RE: Harnett County Land Use Application # 07-5-17721

The Harnett County Department of Public Health, Environmental Health Division on June 13, 2007, evaluated the above referenced property at the site designated on the plat/site plan that accompanied your existing tank application. According to your application requesting a swimming pool, the evaluation was done in accordance with the laws and rules governing wastewater systems in North Carolina General Statute 18A.1950 including related statutes and Title 15A, Subchapter 18A, of the North Carolina Administrative Code, Rule.1950 and related rules.

Based on the criteria set out in Title 15A, Subchapter 18A, of the North Carolina Administrative Code, Rules .1950, the evaluation indicated that the site is **UNSUITABLE** for the addition requested. Therefore, your request for an existing tank is **DENIED**. The site is denied based on the following:

SITE PLAN APPROVAL  
 DISTRICT FAA/CPM USE POOL

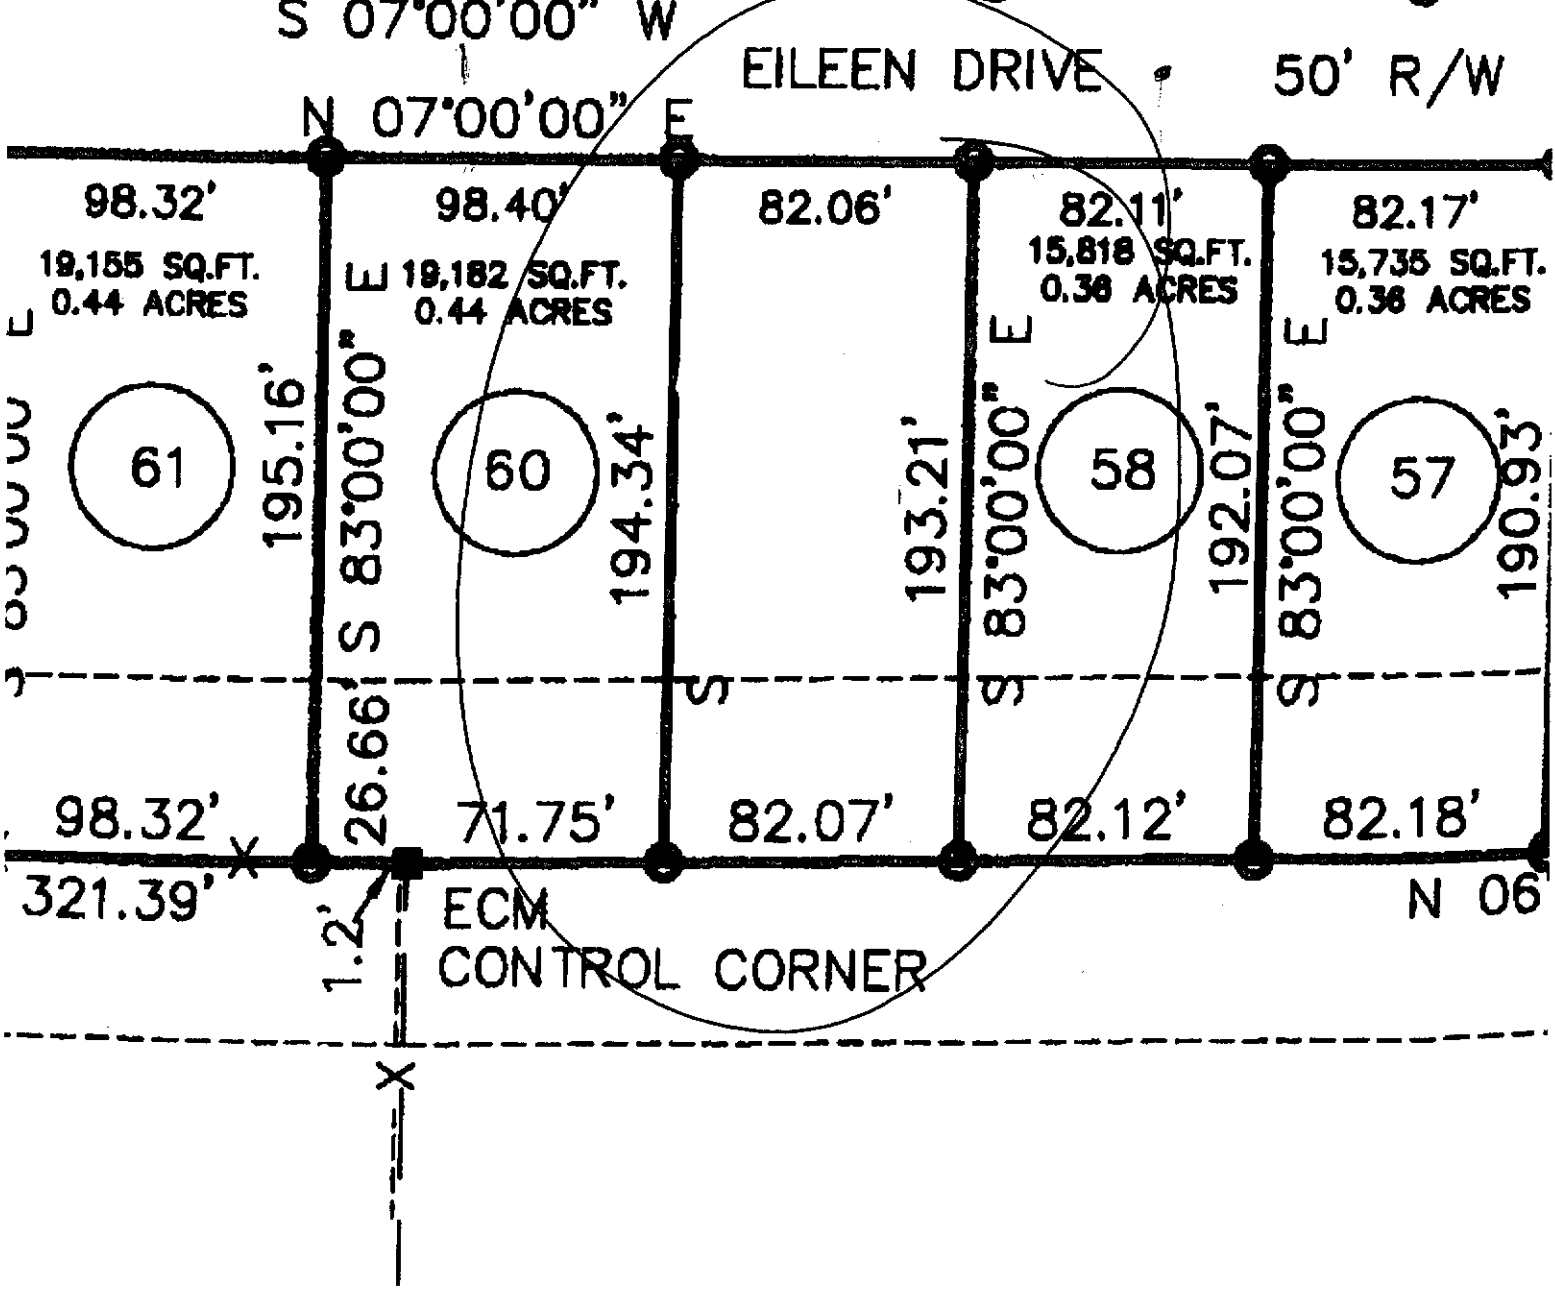
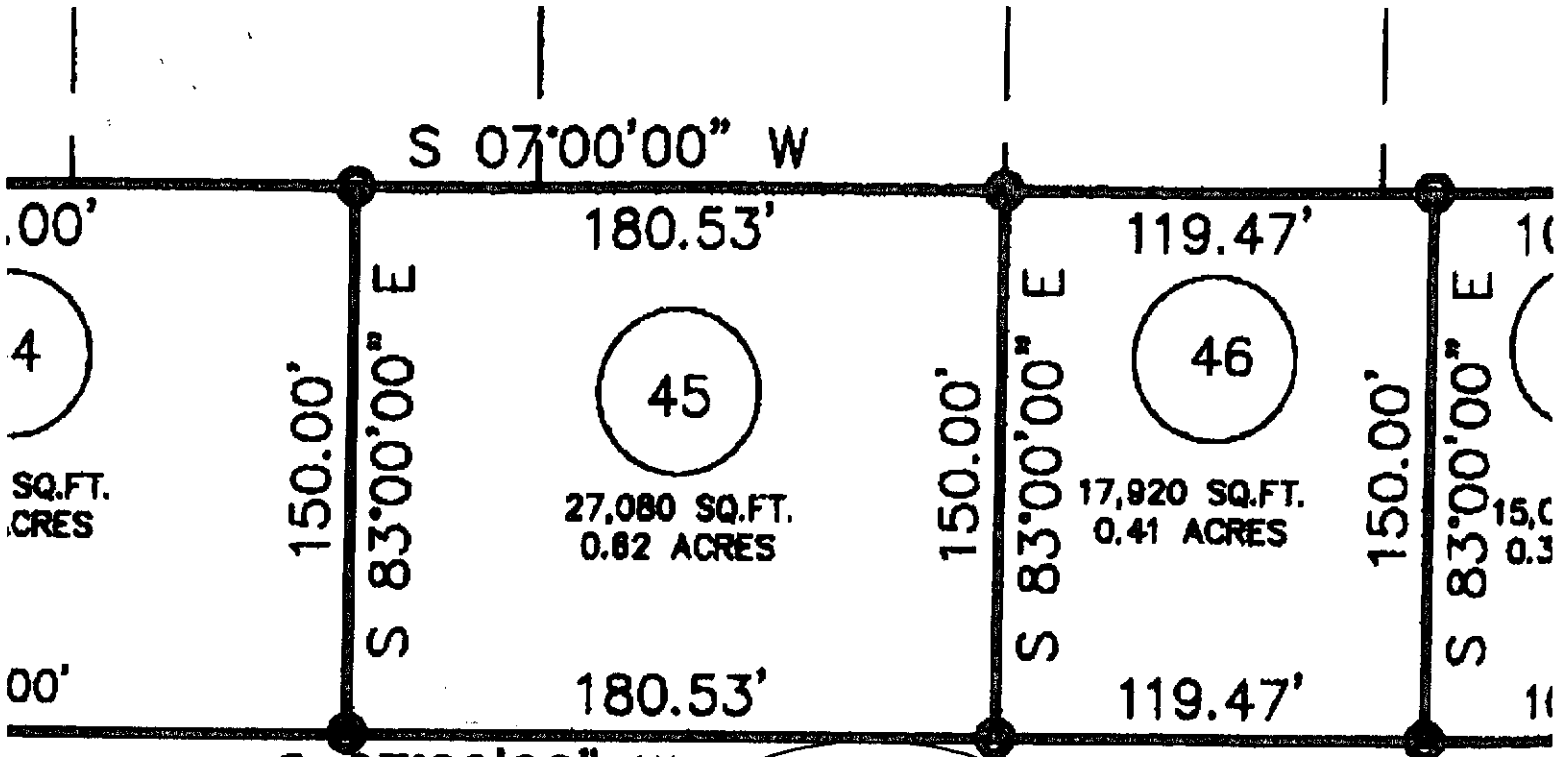
15A NCAC 18A.1950 a(16) Any swimming pool must be 15' from any part of septic system.

15A NCAC 18.1945 (b) Each lot shall have original septic system plus repair area.

15A NCAC 18A.1950 (10) – Any building to be 5' from drain line.
